From: Elizabeth Lawrence [REDACTED]
Sent: 16 July 2021 10:16
To: Simon Davis <Simon.Davis@arun.gov.uk>
Subject: Fw: Planning Consultation on: AL/75/21/PL

Engineers Comments Regarding Surface Water Drainage

The applicant has provided a Flood Risk Assessment [FRA] and conceptual Surface water Drainage Strategy for the site. Groundwater monitoring has been undertaken over winter 2020-2021 at two points on the site, this shows groundwater to peak at 0.75mbgl at WS3 on 29/01/2021. The groundwater monitoring that has been provided is sufficient for the purposes of the surface water drainage design and as such we will not be requesting further groundwater investigation should the application be approved.

Drawing Status	PLANNING		
Client	Melanie Jenkins		
Project	Impermeable Areas		
Drawing Title	Lidsey Lodge Farm Sack Lane, Lidsey PO22 9PE		
Scale	1:750	Date	Jun 2021
Drawn By	DJL	Checked By	LDF
Drawing No.	D1922-102		Rev. A

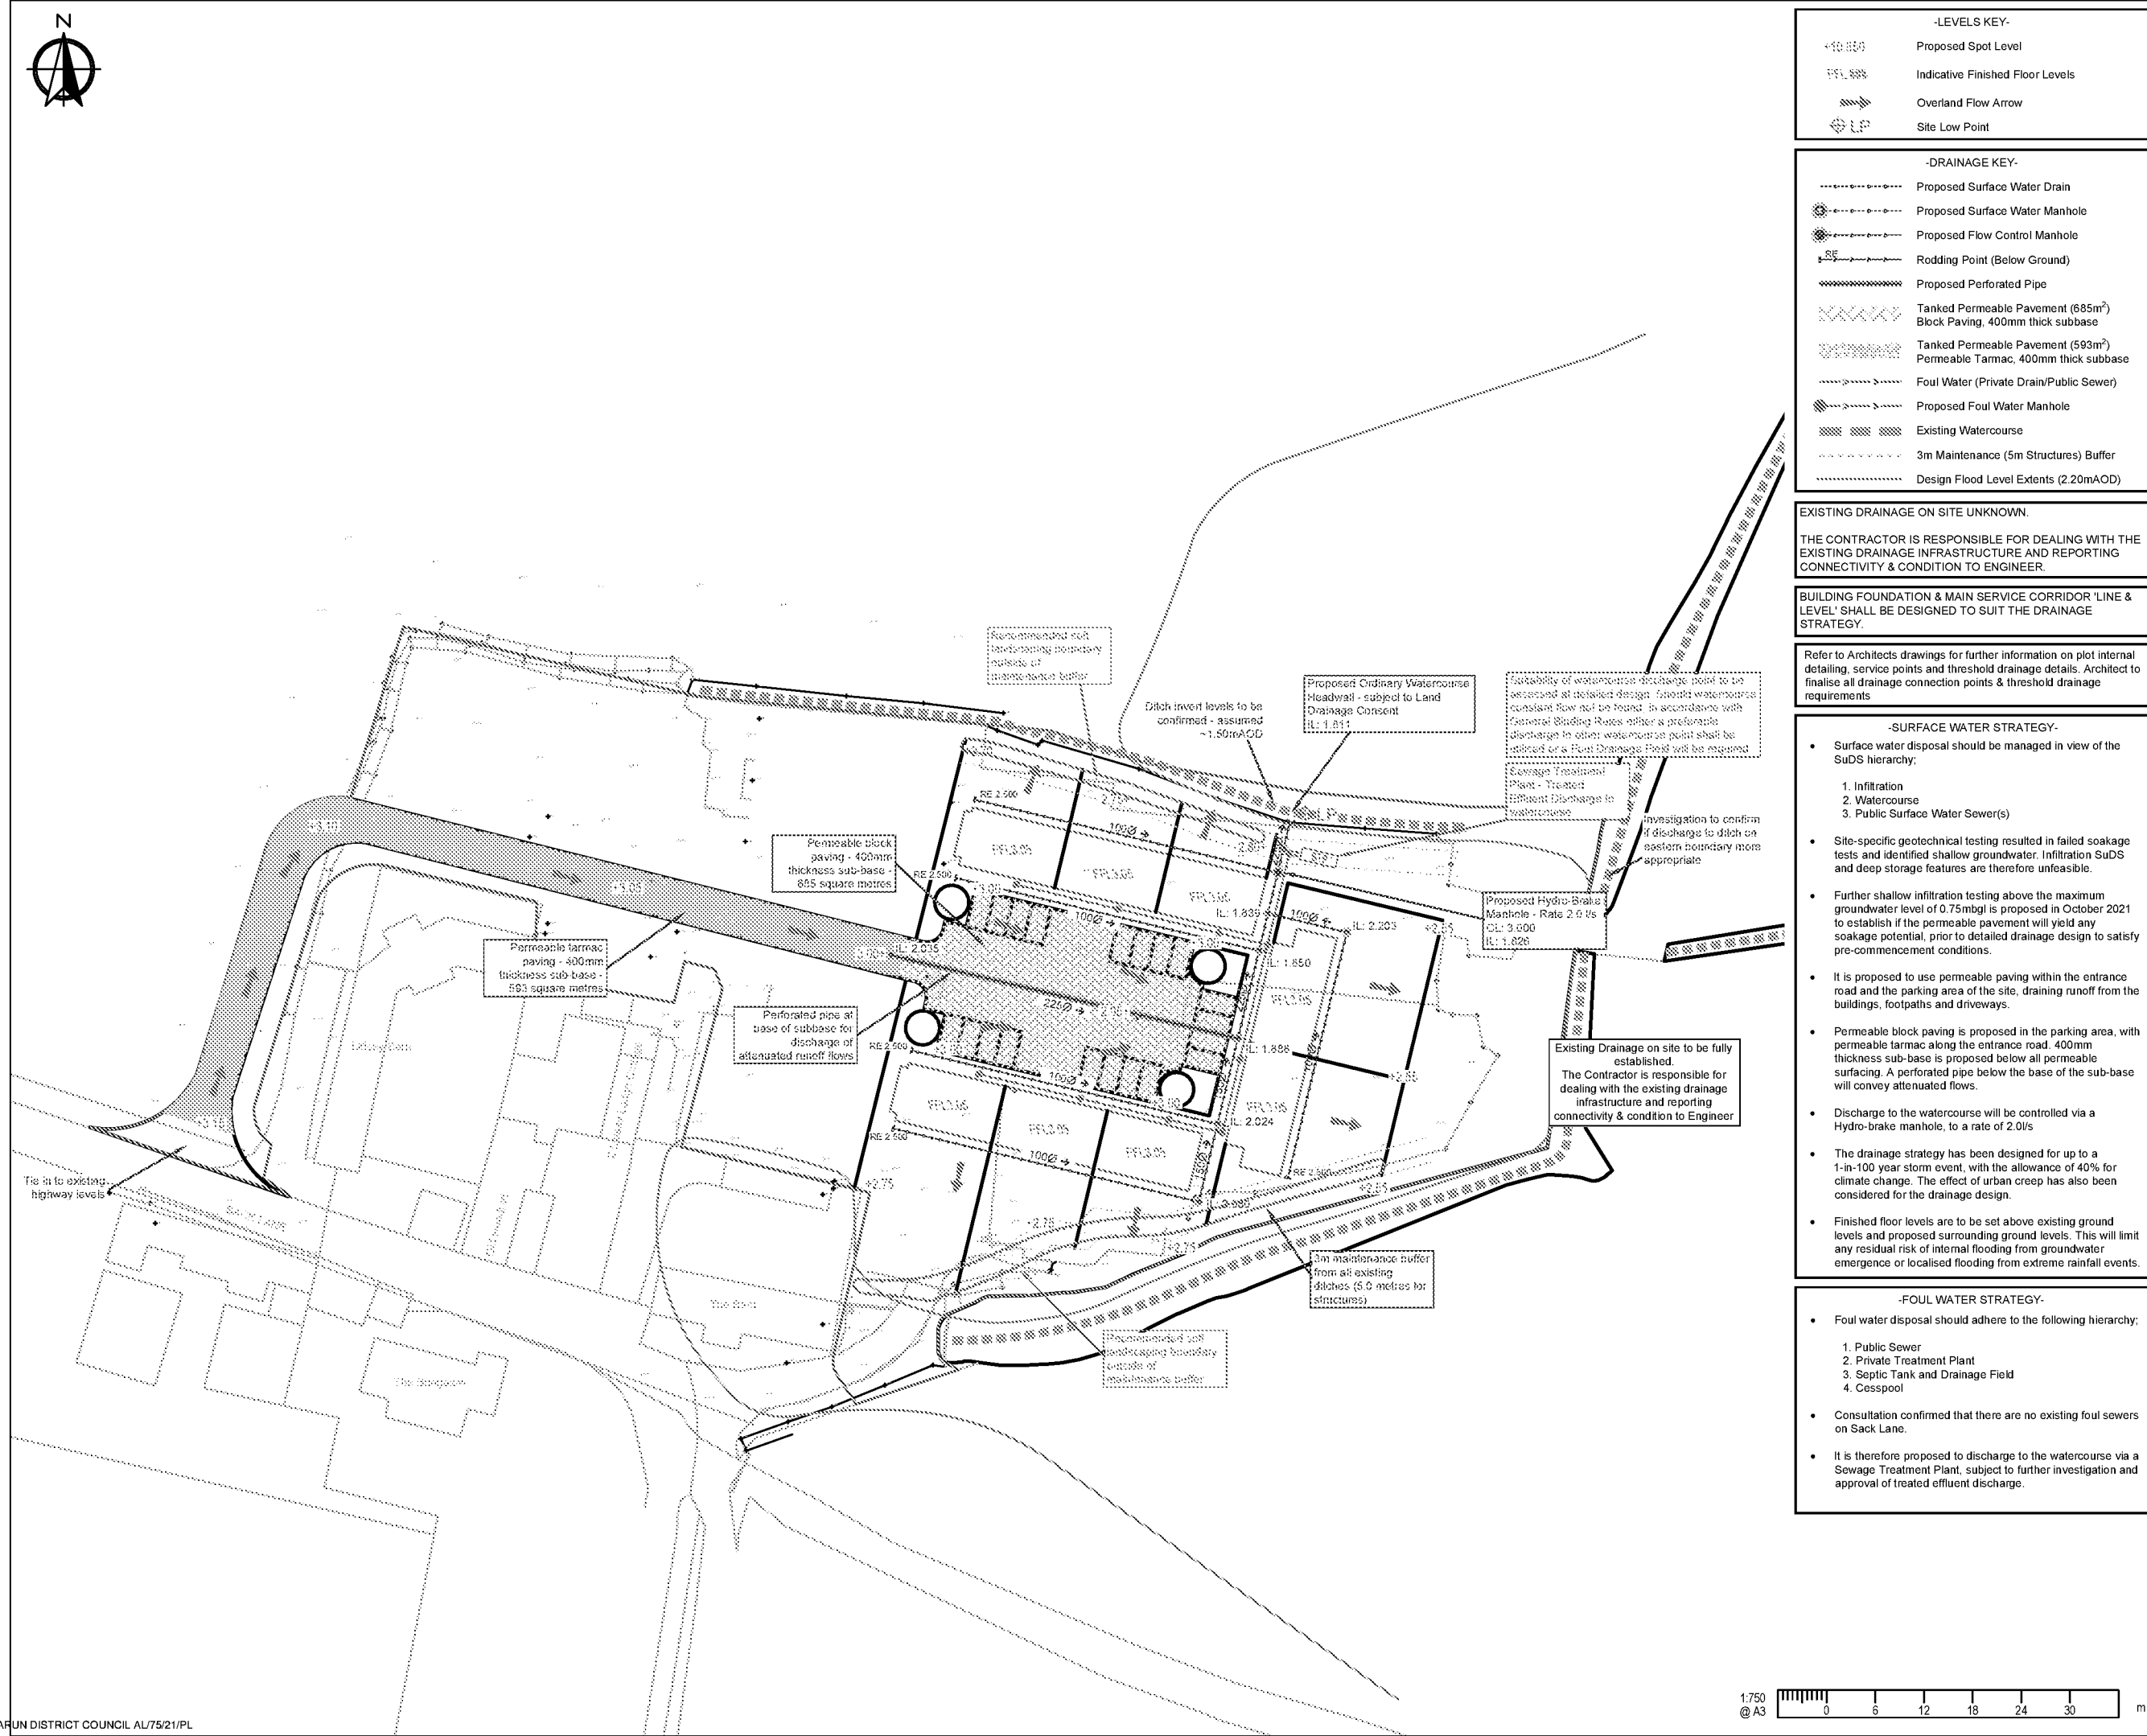
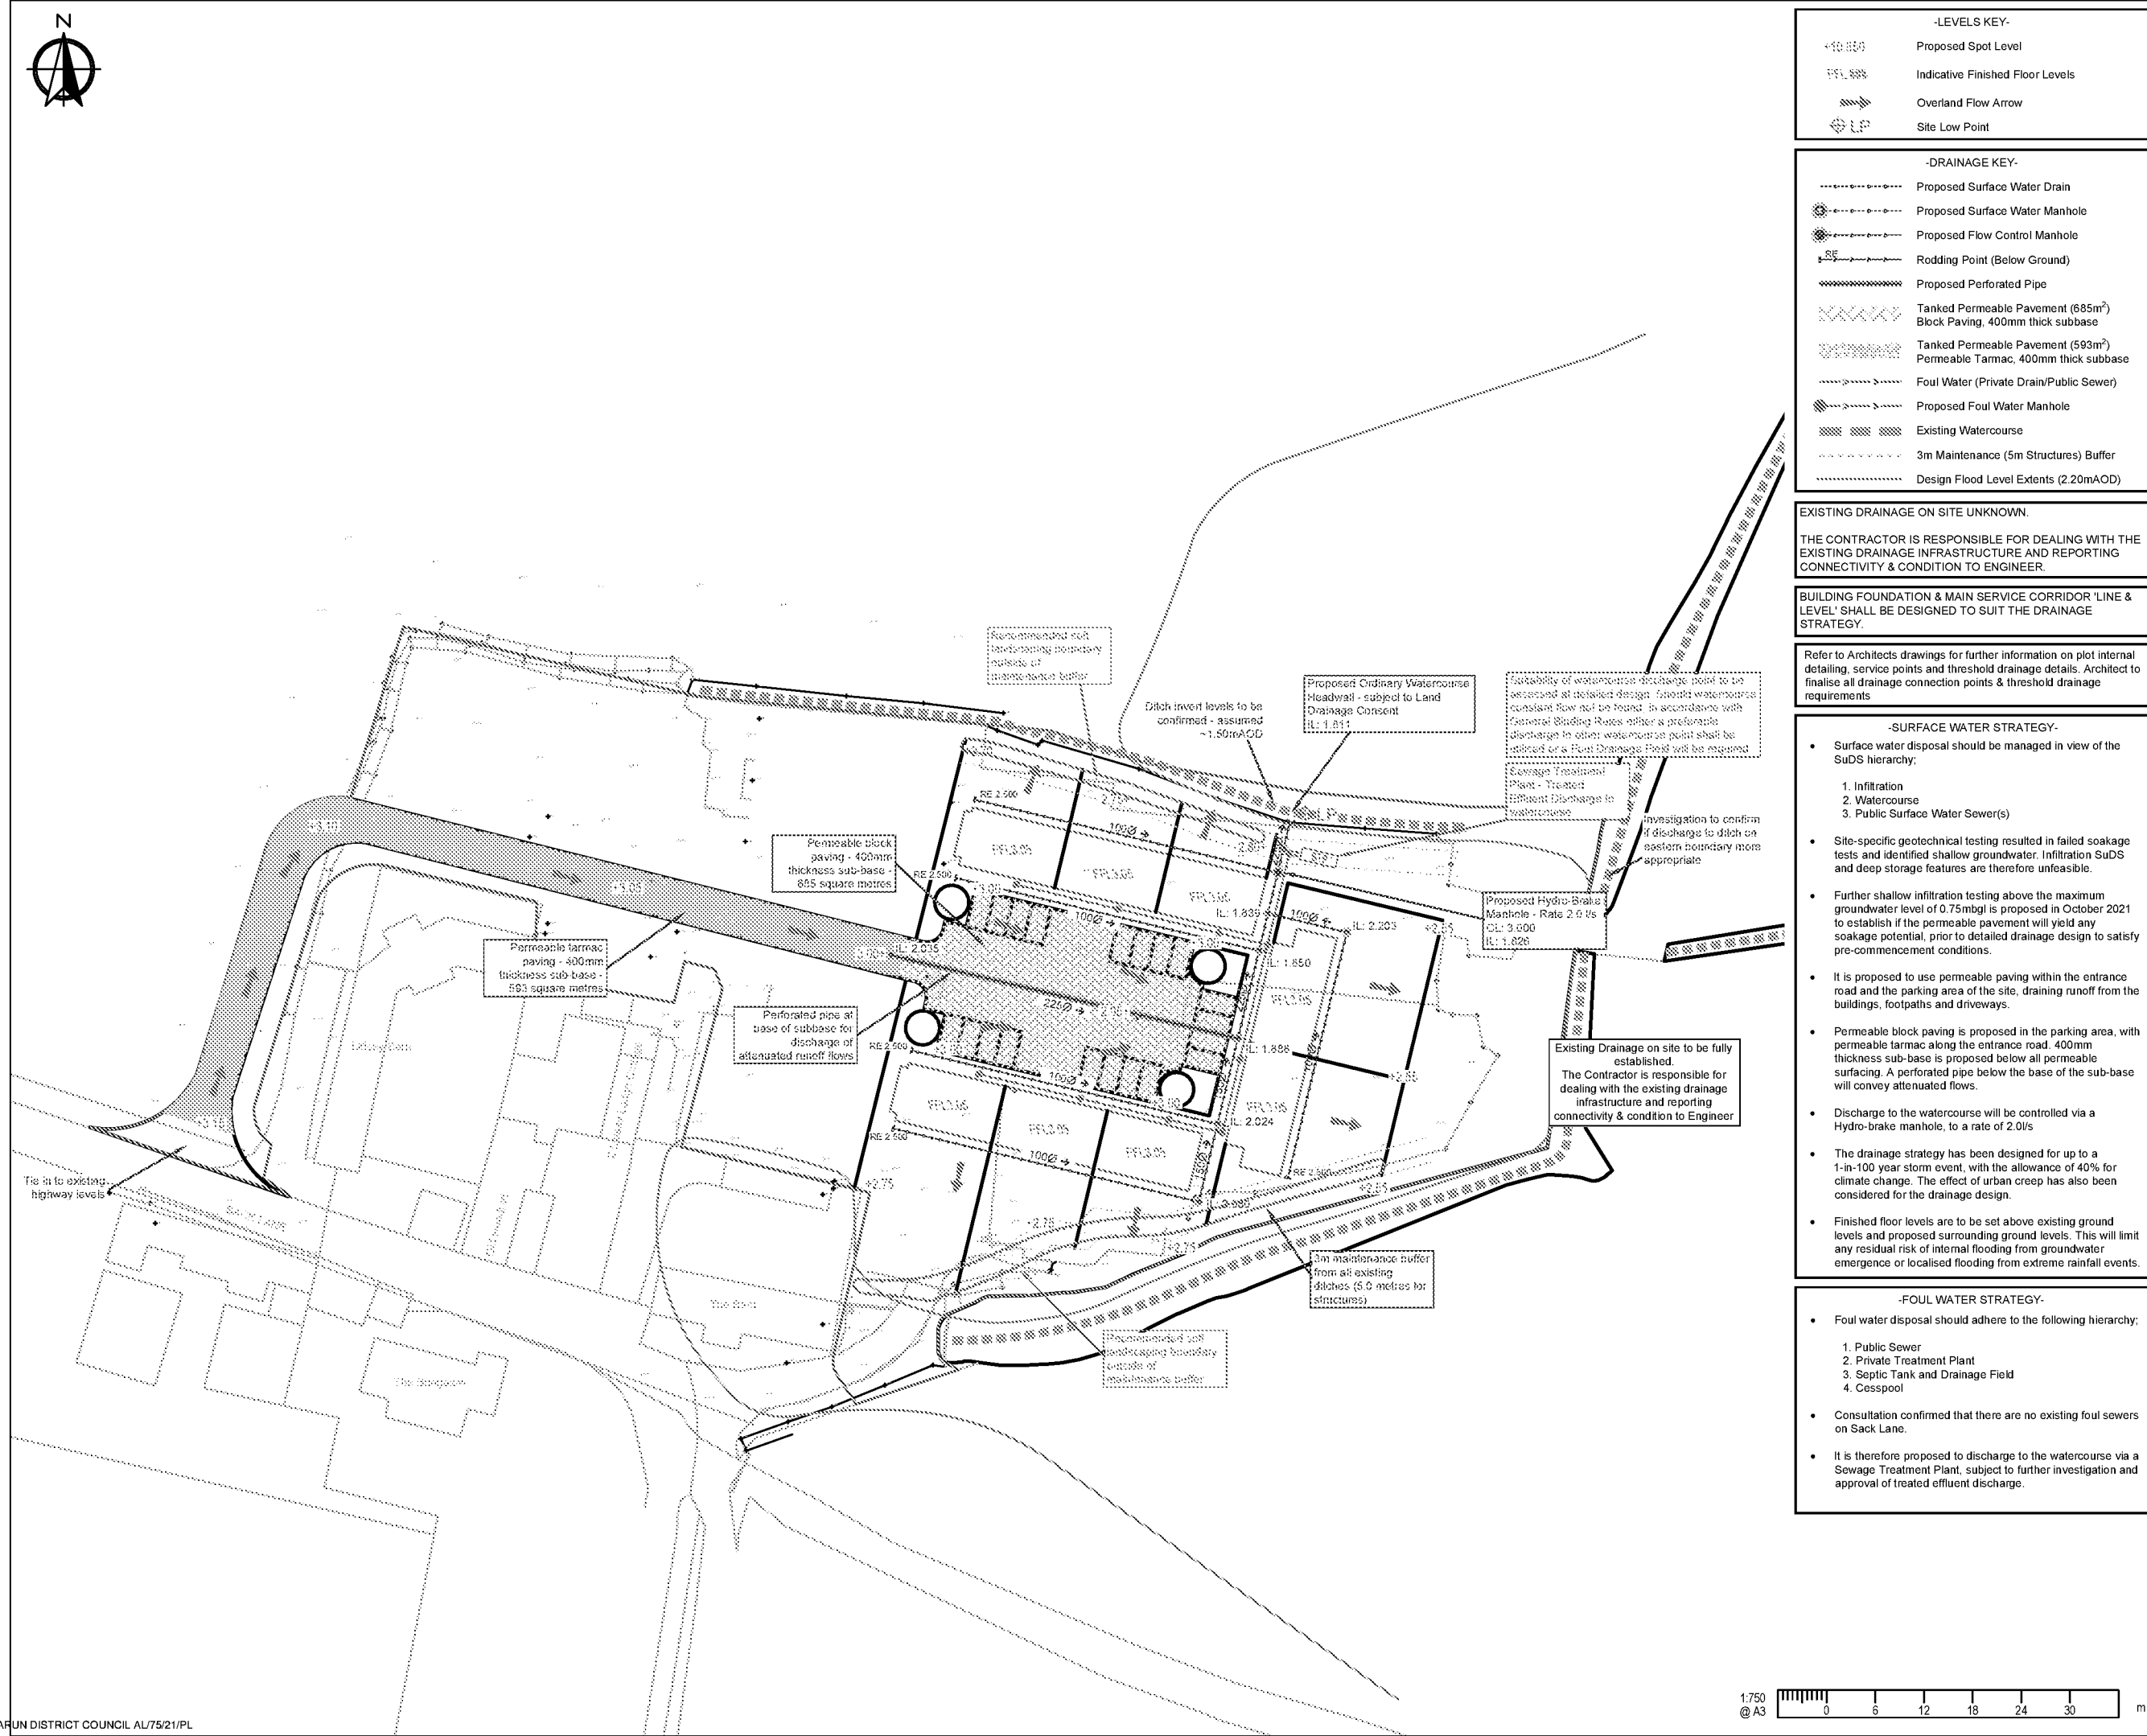
If it is believed that infiltration will not be possible on the site, the applicant may wish to undertake the DG365 testing now, as if infiltration is not viable in Spring/Summer, it certainly won't be in winter. However, if summer testing shows infiltration to be viable then we will expect the tests to be repeated in the winter period. The infiltration tests should be completed in the location of the proposed permeable paving and at shallow depths (above peak groundwater level).

Assuming that infiltration is found to not be viable on the site, then the applicant proposes to dispose of surface water via permeable paving which provides water treatment and storage before discharging at a restricted rate of 2l/s to the watercourse at the north of the site. We are agreeable to this solution, as groundwater did not peak above 0.75mbgl we would like to see the permeable paving lined with a permeable liner to make use of whatever limited infiltration potential there may be on the site.

The applicants engineers are aware of the required easements to the watercourse as these are cited within the FRA. Please ensure that not only buildings, but also boundary fences are not sited within 3m of the watercourses. Please provide a plan showing the buffers and the flood zones when a Discharge of Conditions application is made (if this application is approved).

As per our previous response (attached), winter infiltration testing at a shallow level above 0.75mbgl where the permeable pavement is proposed will need to be undertaken as part of the detailed design to discharge these conditions.
